Planning Application: 22/03049/OUT

Location: Land West of Oxford Close and North of Corner Farm, Station Road, Kirtlington

Description: Provision of eight dwellings with access, parking and amenity space.

Comments from Kirtlington Parish Council

**Figure 2.4 Location of Accidents**

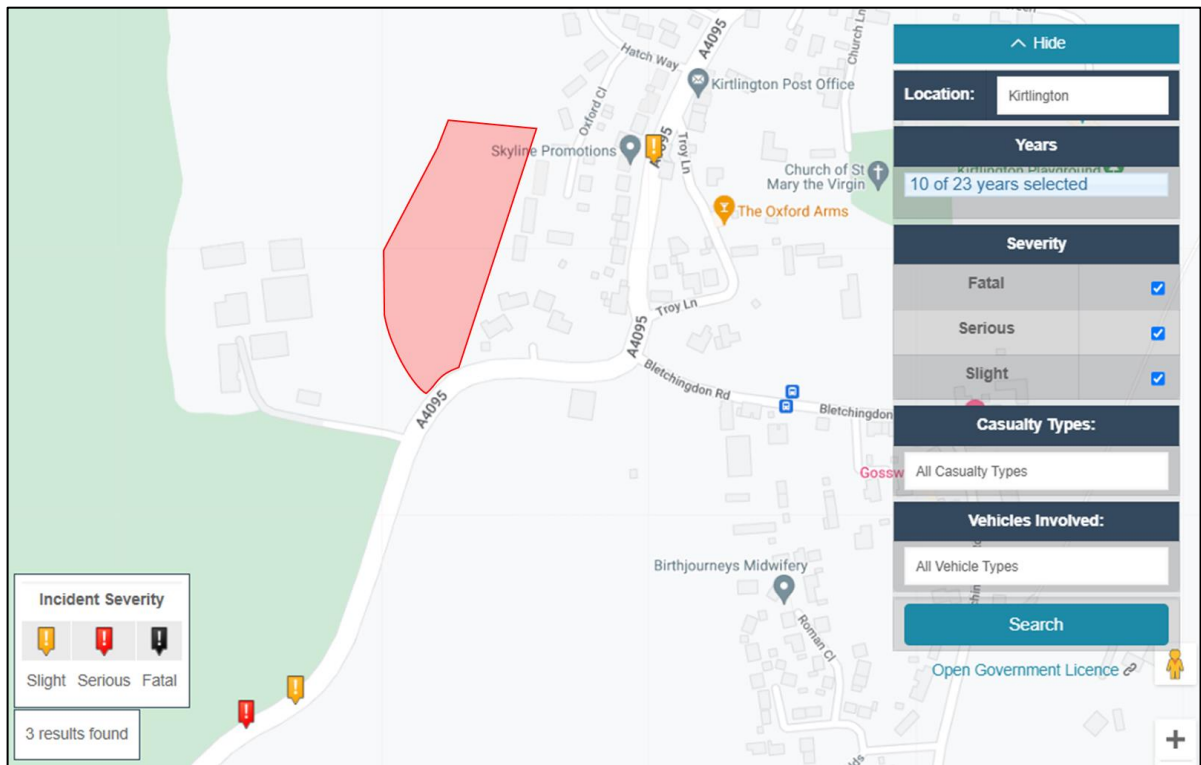
Item 9: The Parish Council notes the objection received from OCC Highways (dated 1st November 2022), particularly where “*the proposed access is positioned on a corner that features a prominent crest, limiting visibility*” which acknowledges how dangerous this sharp corner on a fast approach to the village really is. For pedestrians, the proposals do show a planned pedestrian link from the site to the existing footway network (TPA drawing 2207-015 PL01A), but the requirement for over 50m length of new footpath demonstrates that the site is not readily accessible or connected to the rest of the village.

SCALE: 1:500	DATE: 02.09.22	DRAWN: TW	CHECKED: DF	APPROVED: DF
JOB NO: 2207-015	DRAWING NO: VS01	REVISION: A

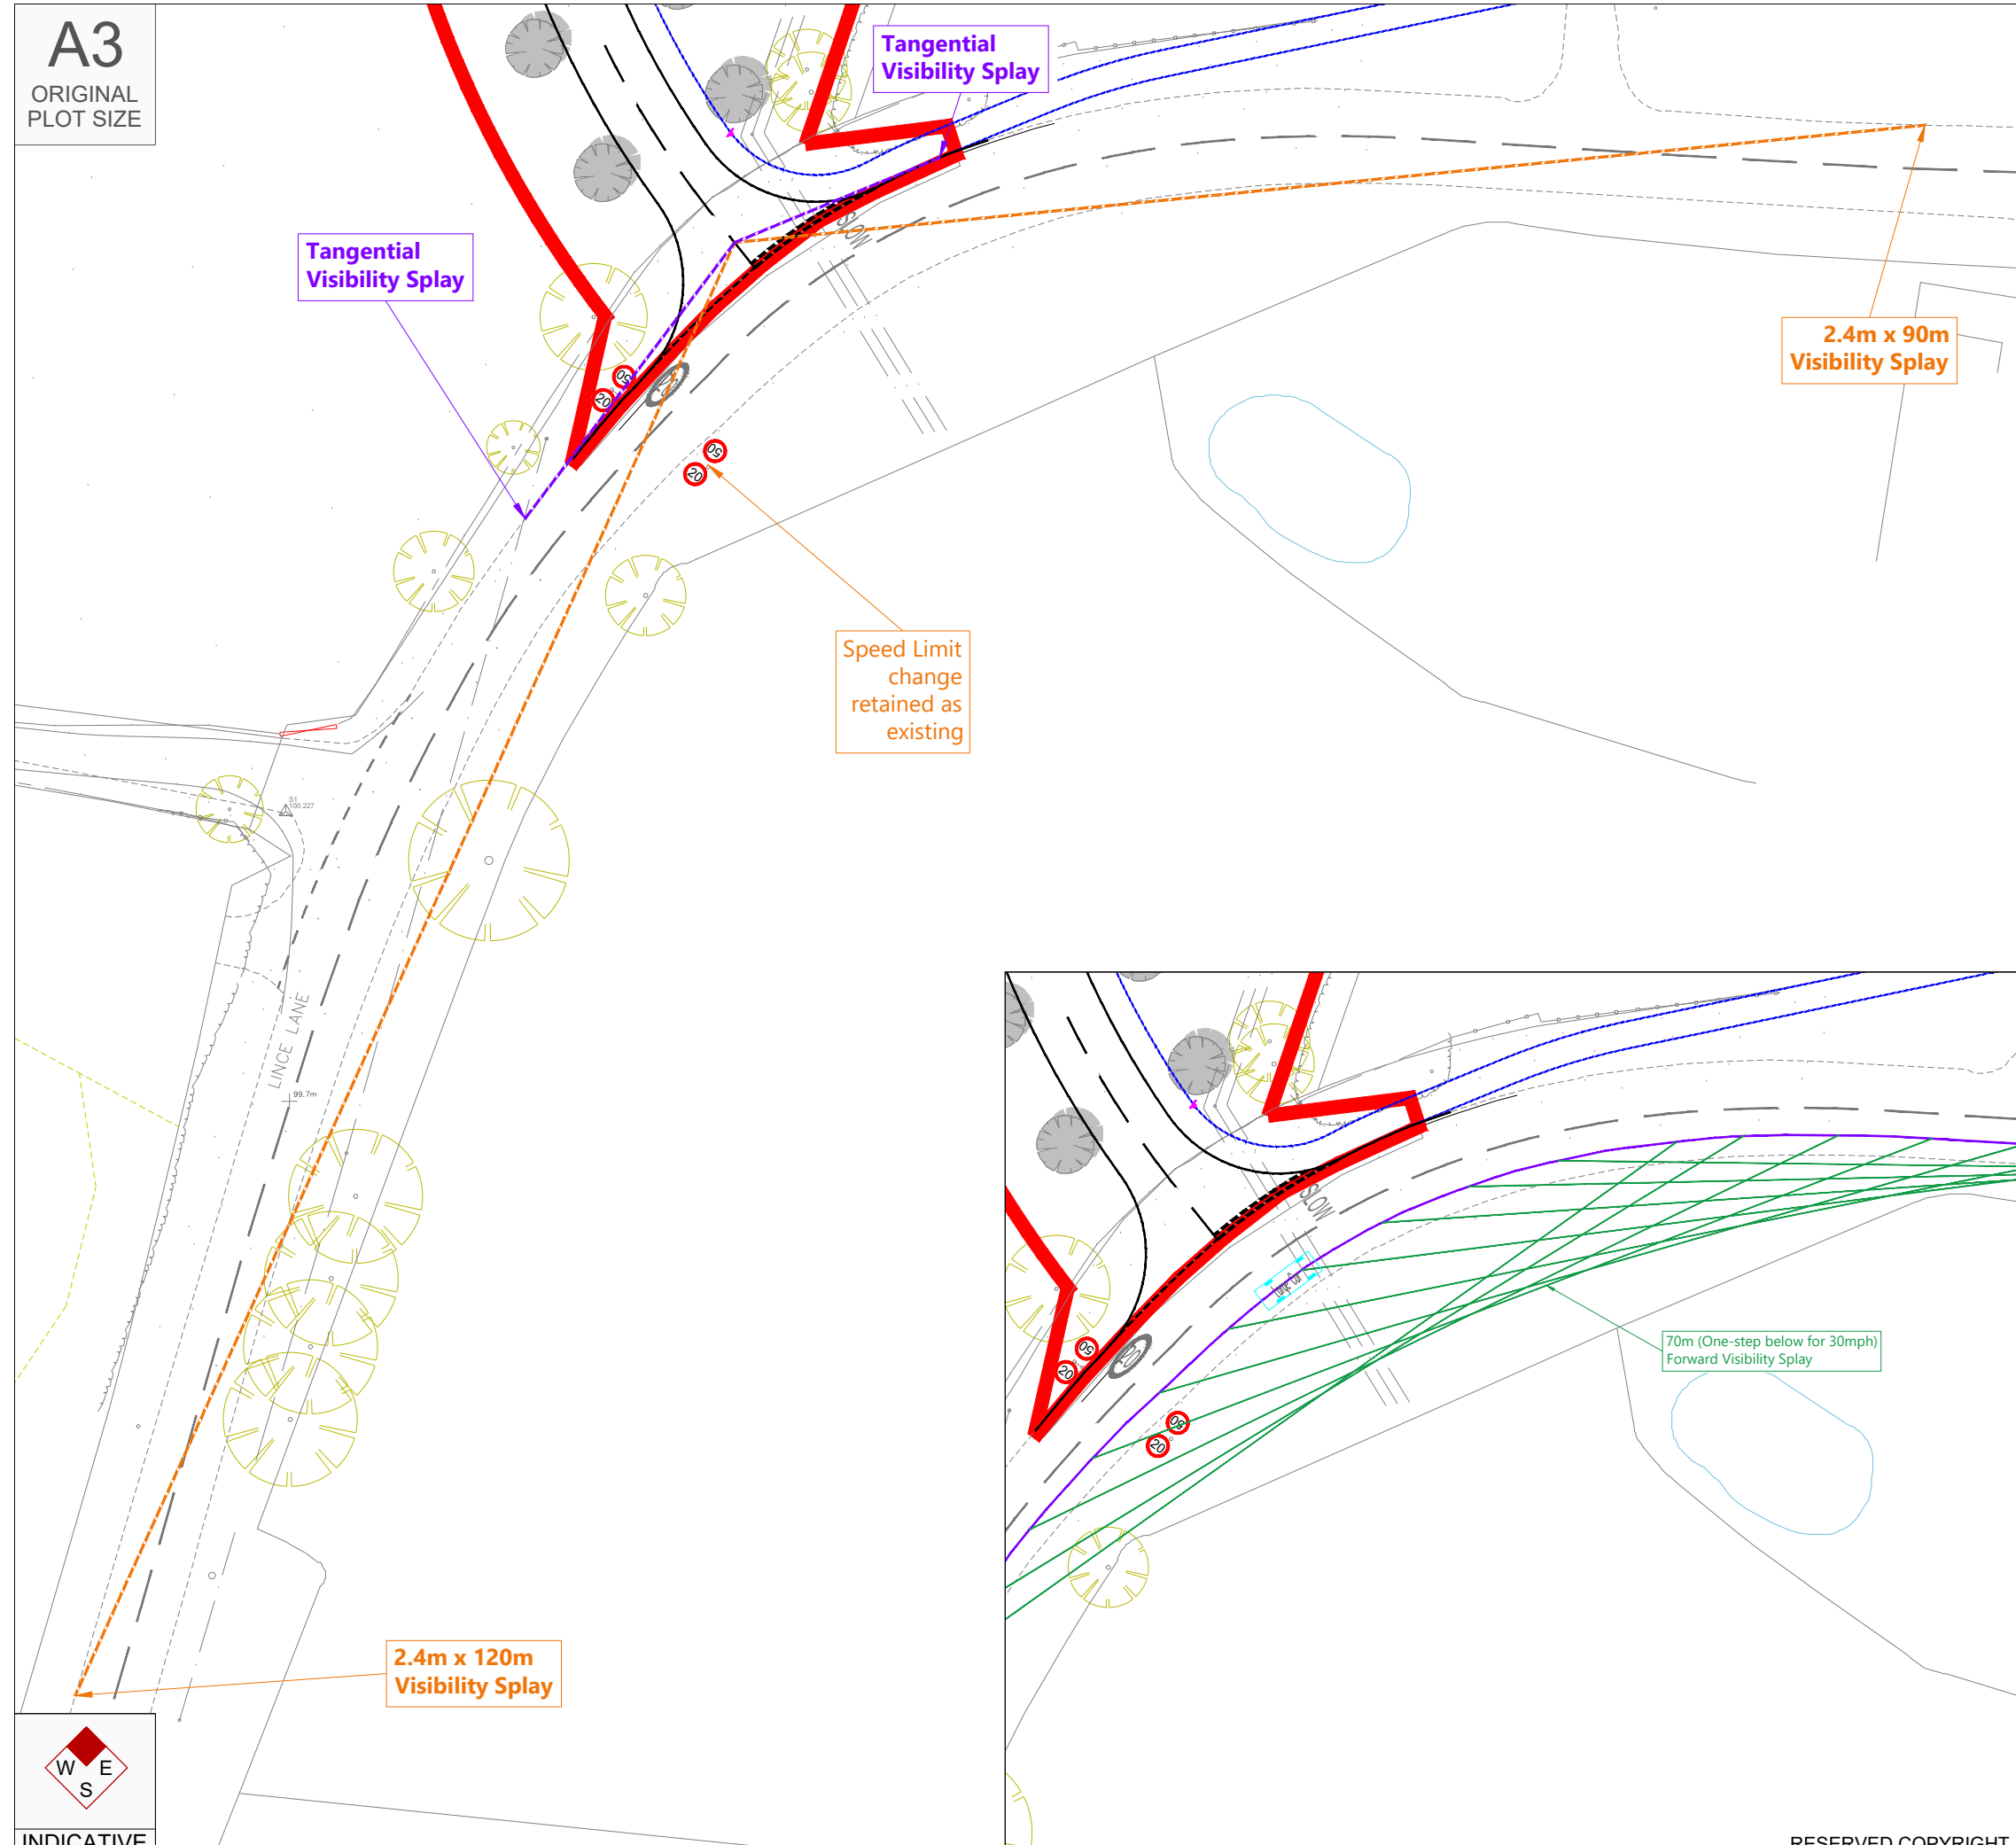
9. The access location for the site is a road safety risk. The access is on a corner at the blind brow of a hill. Sight lines are severely compromised as traffic approaching from the south can neither see nor be seen. (See attached photograph, Kirtlington blind bend).
10. There are deficiencies in the plans regarding the mix of houses and number of car parking spaces per plot, with too little parking for the size and number of houses outlined.
